# TERRA RIDGE NORTH CIVIL CONSTRUCTION PLANS El Paso County, Colorado

INDEX OF SHEETS	
SHEET NUMBER	SHEET DESCRIPTION
C1	COVER
C2	NOTES
C3	GENERAL NOTES AND ROADWAY SECTIONS
C4	ROADWAY KEY MAP SHEET
C5	PLAN AND PROFILE
C6	STORM PLAN AND PROFILE
C7	DETENTION POND STRUCTURE AND EMERGENCY OVERFLOW SECTION

EL PASO COUNTY DEVELOPMENT  
REPLAT TERRA RIDGE LOTS 5 & 6 W/ 11 LOTS IN  
TERRA RIDGE NORTH  
COVER SHEET

RURAL LOCAL – PAVED  
 TYPICAL SECTION  
 SCALE N.T.S.

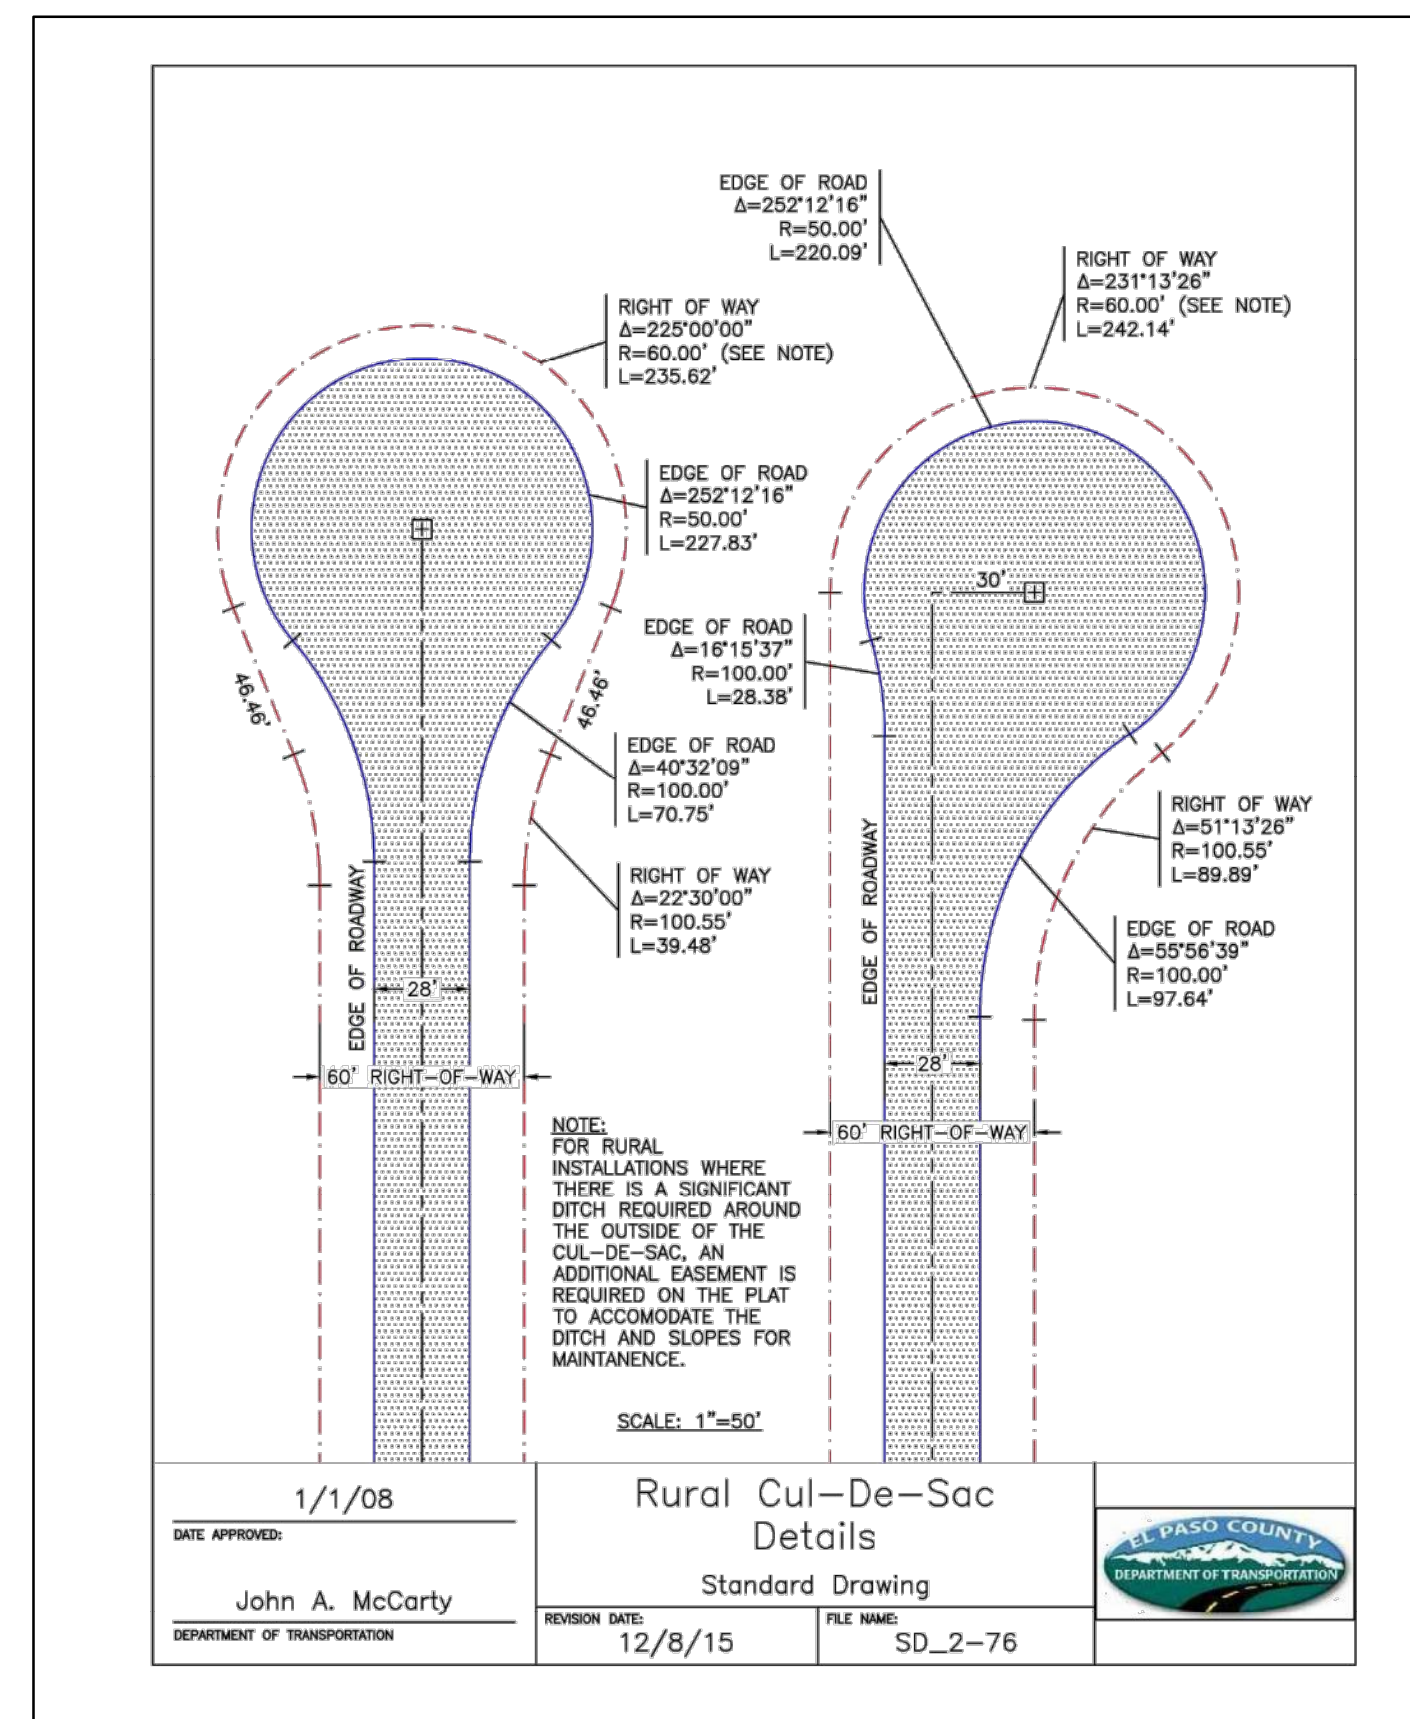
List proposed speed limit for road.

Delete note
